19 December 2017

**SSD 7348 – Oakdale West Industrial Estate – Concept Proposal and Stage 1 Development**

WaterNSW has also reviewed the EIS and associated documents and provides the following comments specific to this development:

STORMWATER DRAINAGE CATCHMENT PLAN (POST-DEVELOPED)

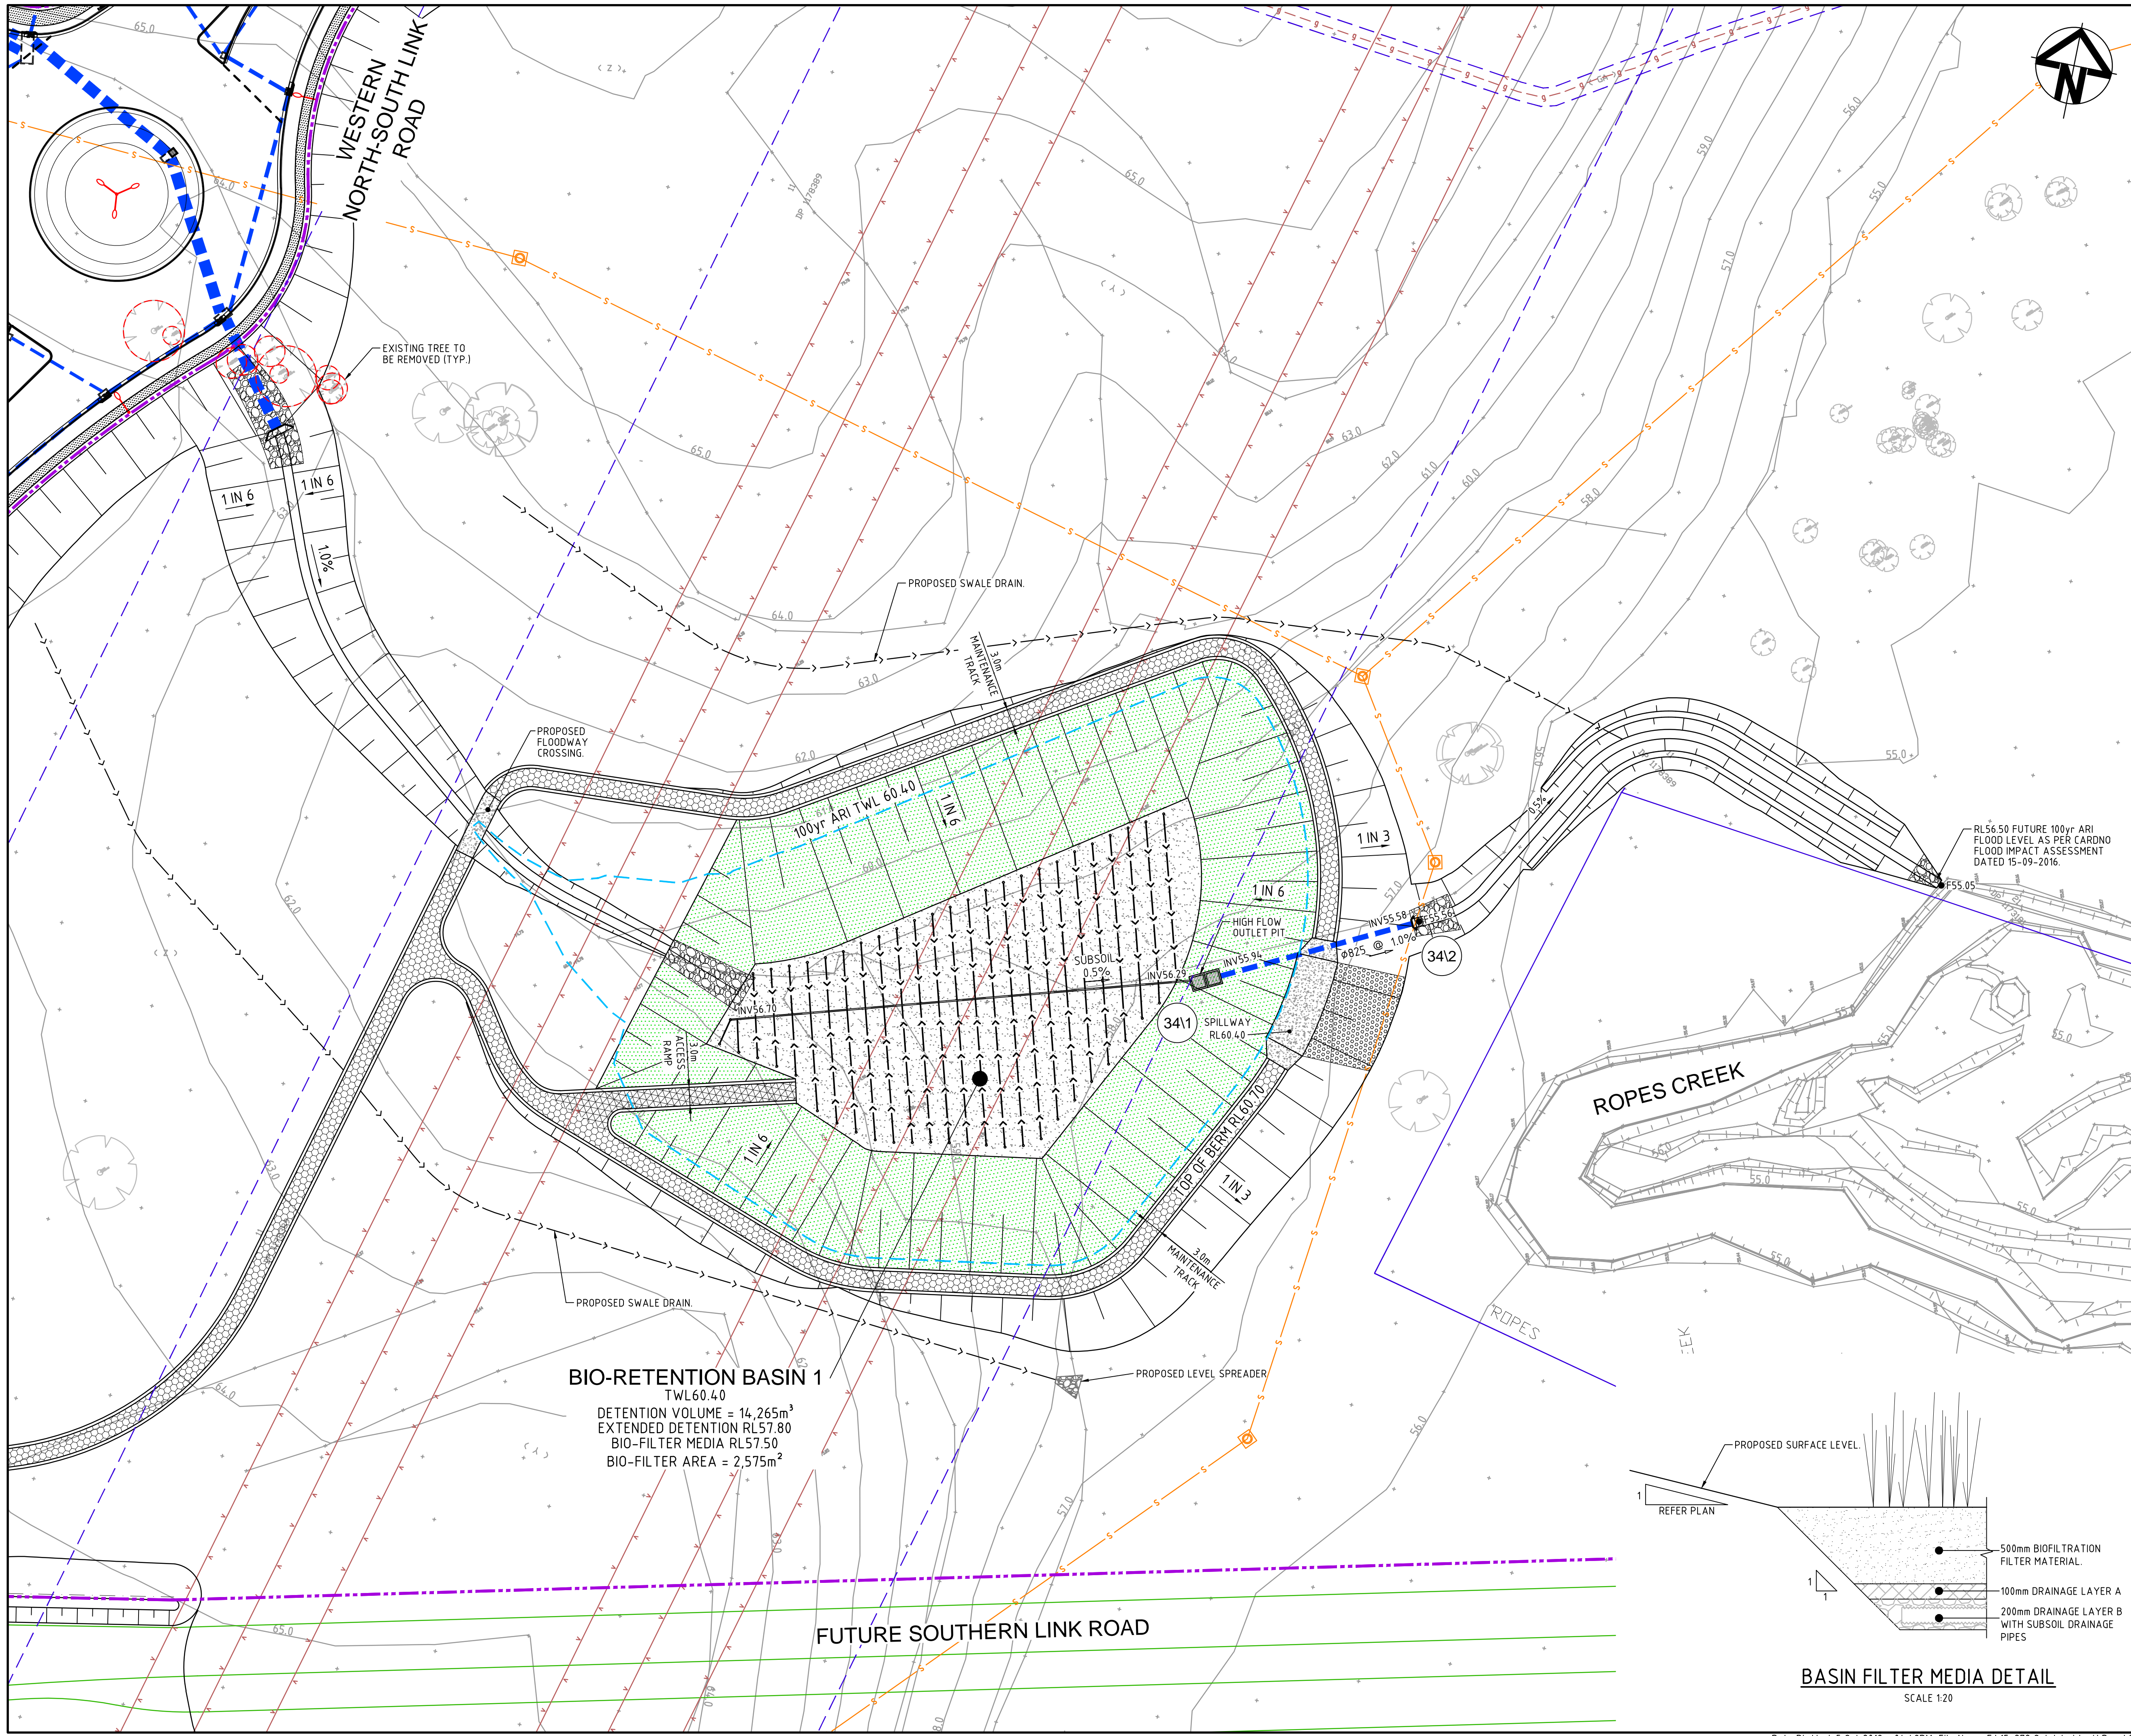
WaterNSW notes that the final discharge of treated stormwater will follow through the existing stormwater cycle into Ropes Creek or other local swales and waterways around the Site (Urban Design Report p53). The Stormwater Drainage Catchment Plan shows discharge point A into Ropes Creek and discharge point B into a local swale, both flowing across the Pipelines corridor. However, there is also a further discharge point coming from the large dam on the northern boundary of the development site into the Pipelines corridor near the valve house (the brick structure at the low point of the pipeline) which continues into a tributary of South Creek on the northern boundary of the corridor.

Development drawings currently show that bio-retention basin 1 (which replaces the large dam) will drain towards bio-retention basin 2 and together they will discharge at point B, across the Pipelines corridor, avoiding the valve house discharge point. The combined flow at this point, must not exceed the culvert's capacity.

Changes in drainage and stormwater may increase flooding, subsidence and erosion. WaterNSW requests that stormwater drainage be designed to comply with the requirement that post development peak stormwater flows are no greater than pre-development peak stormwater flows. The development, including all earthworks, dewatering of the existing dam and changes in levels and impervious areas due to the development, must not cause the stormwater flows into the Pipelines corridor to increase above their current levels.

- *No peak stormwater flows exceeding the existing levels shall enter WaterNSW drainage lines or the Pipelines corridor from the development site.*
